Application no: H02/0975/02

Applicant: R V Evans  
Peak Hill  
Cowbit Bank  
Cobit  
Spalding, Lincs, PE12 6AW  
Description: Proposed bungalow and garage (Outline  
application H02/0899/99)

Location: Adj. 3 Cluttons Close  
Crowland

Amendment: Revised position of bungalow  
Dwg.No.SH/86502. Sheet 3 of 3

Drwg no. SH/86502. SHEET 3 of 3.

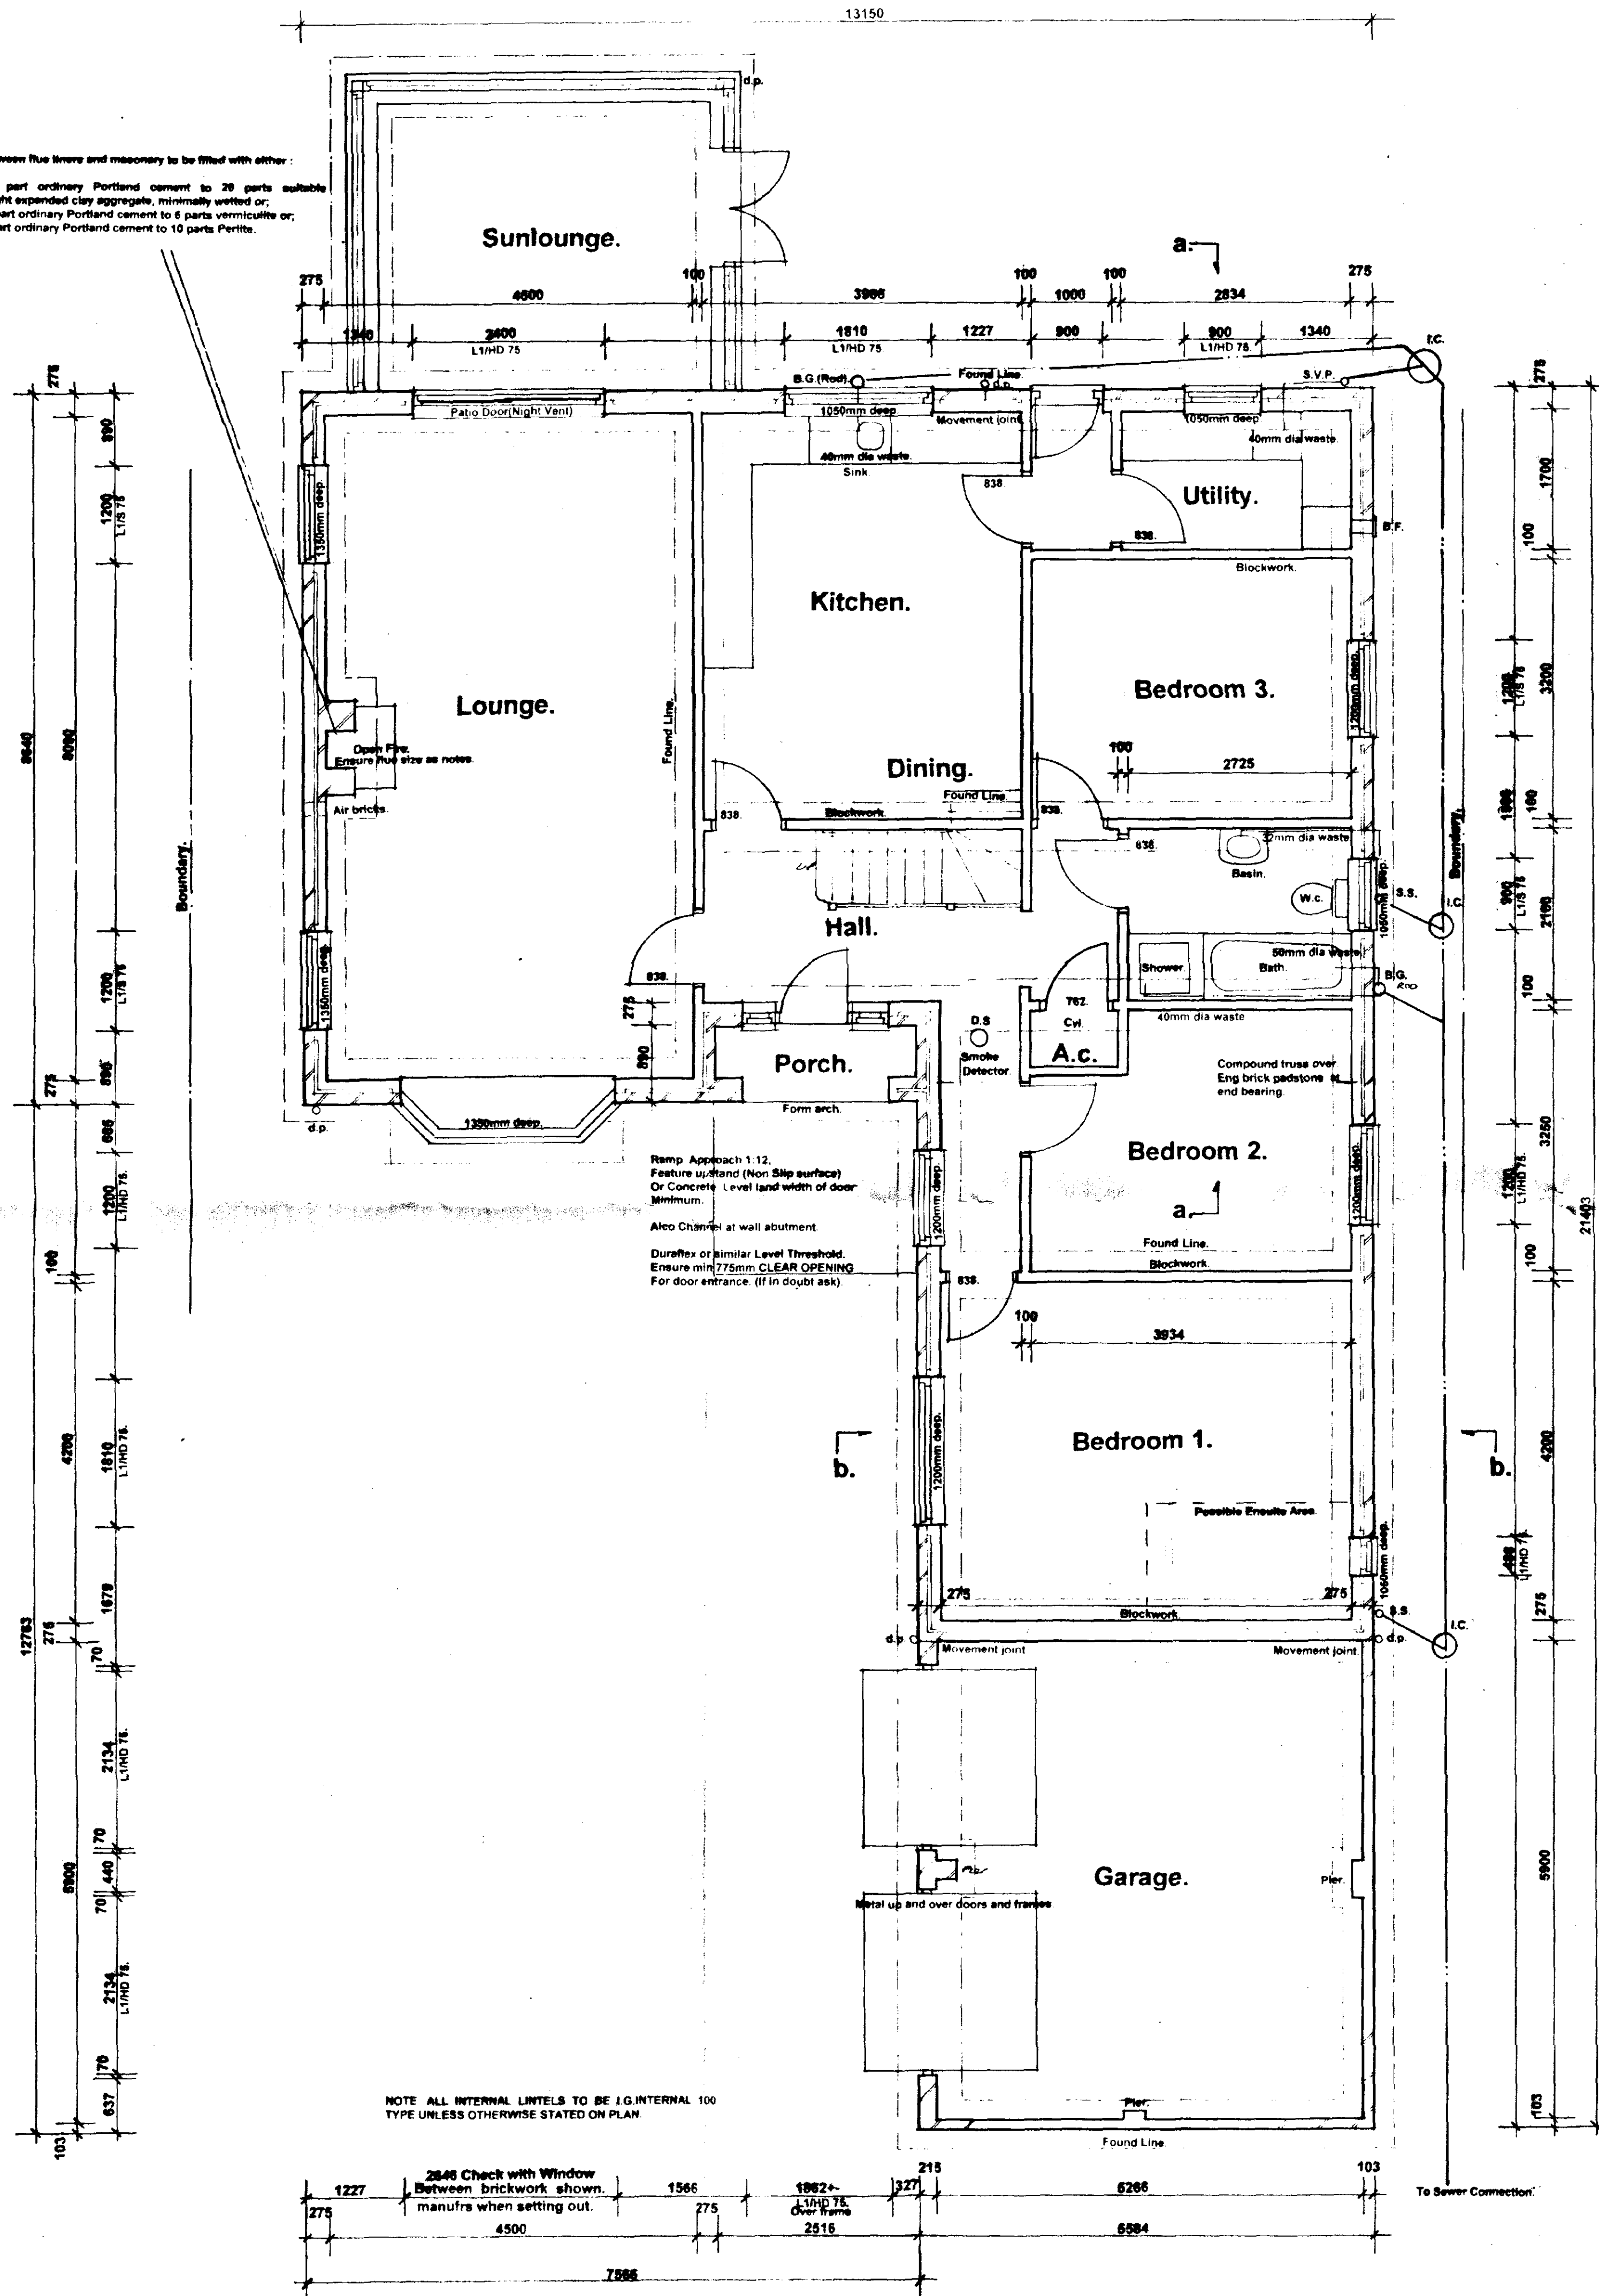
I enclose Amended Site Plans now showing the Bungalow further forward as discussed.

Drwg no. SH/86402. SHEET 1 of 3.

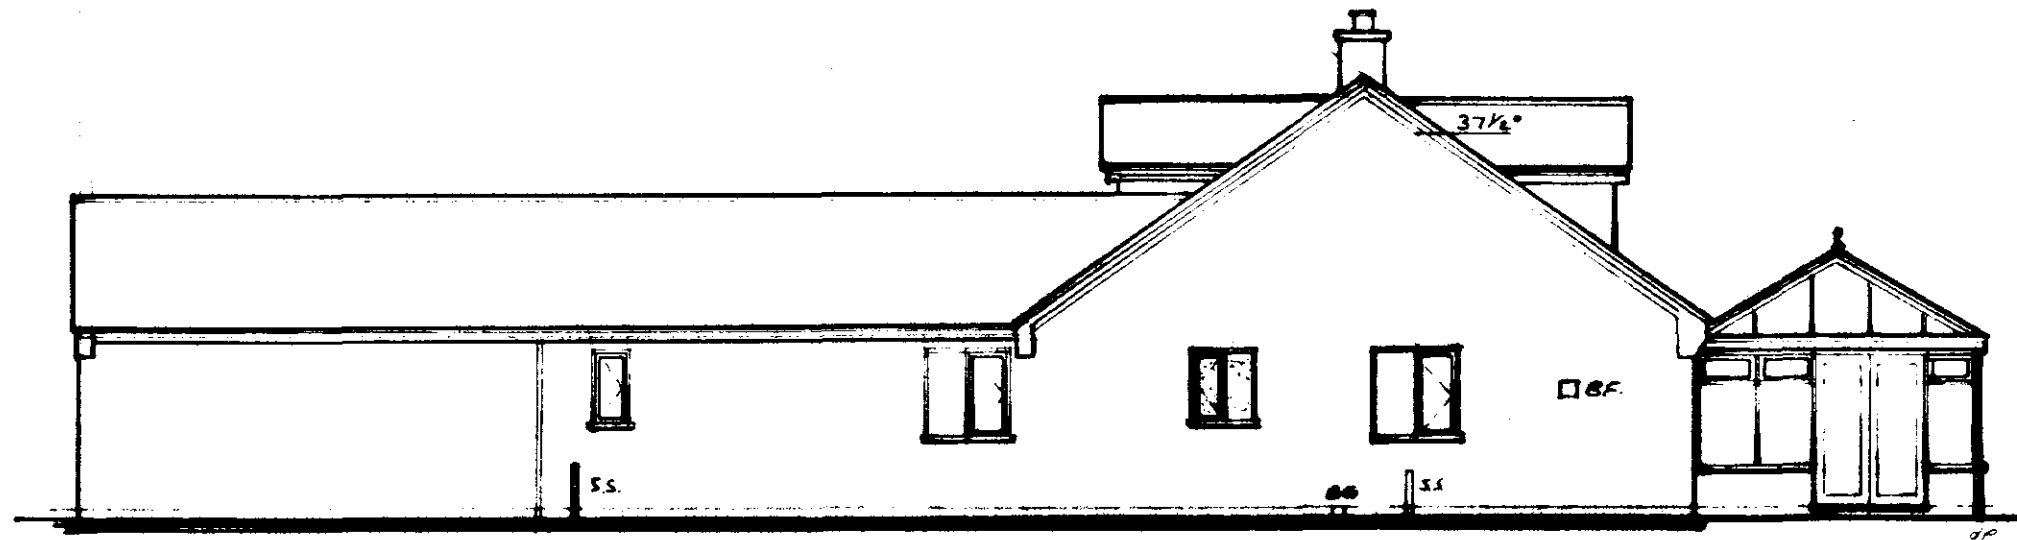
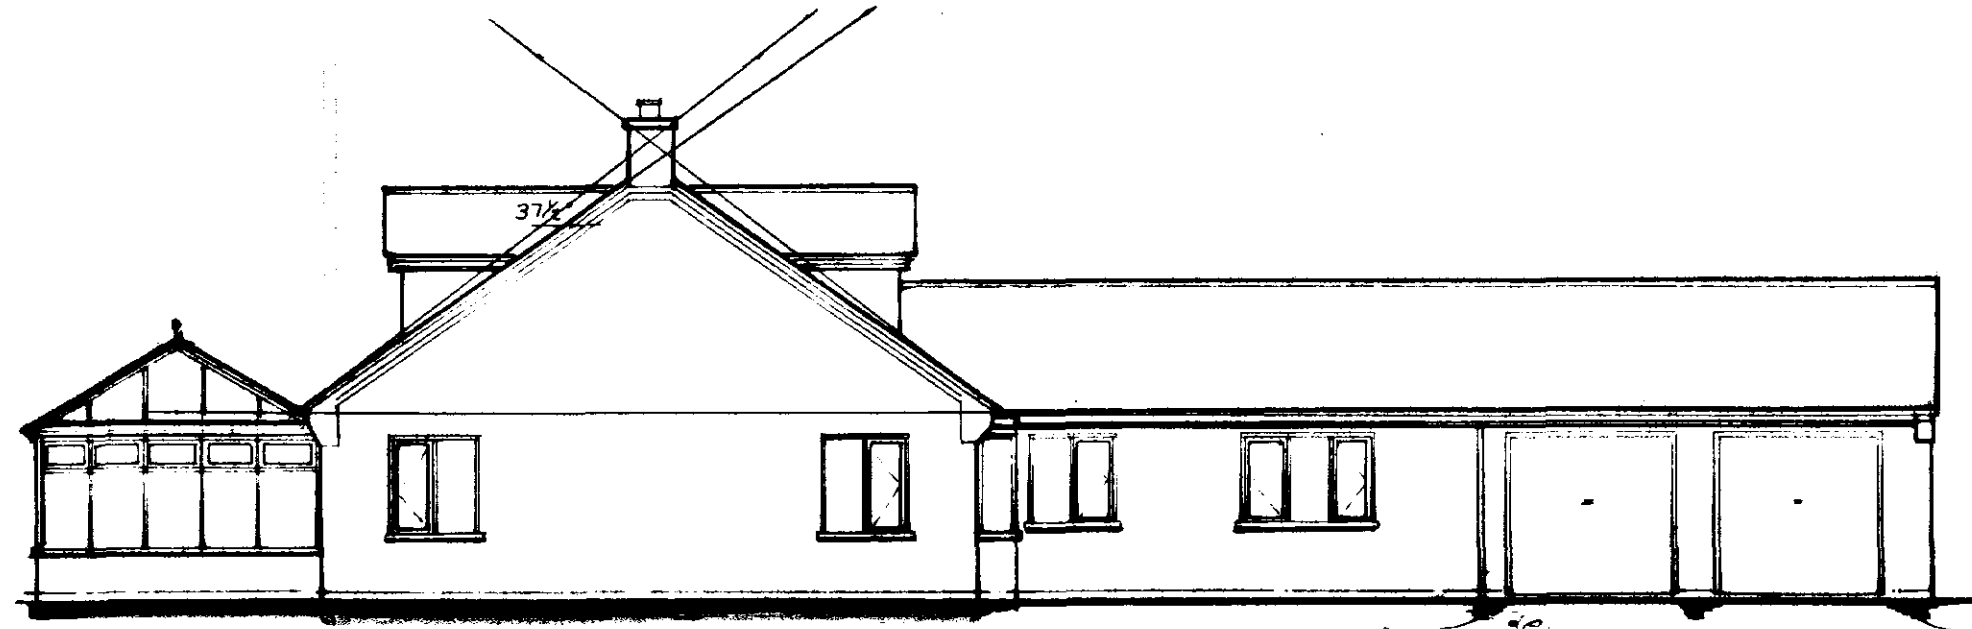
**Amendment:** Raise roof pitch from 35degrees to 37.5degrees & insert five dormer windows (Dwg. nos. SH/86702 & SH/86402)

FORMATION OF LOFT AREA  
& DORMER WINDOWS ALONG  
WITH STAIR ACCESS.  
ALSO 35° PITCH TO MAIN  
ROOF TO BE 37½°.

Roof ridge max h  $\geq$  300 mm.

3 rear dormers Pd are built & occupied.

2 front dormers need PP, approx 23 m from boundary on opposite side of road
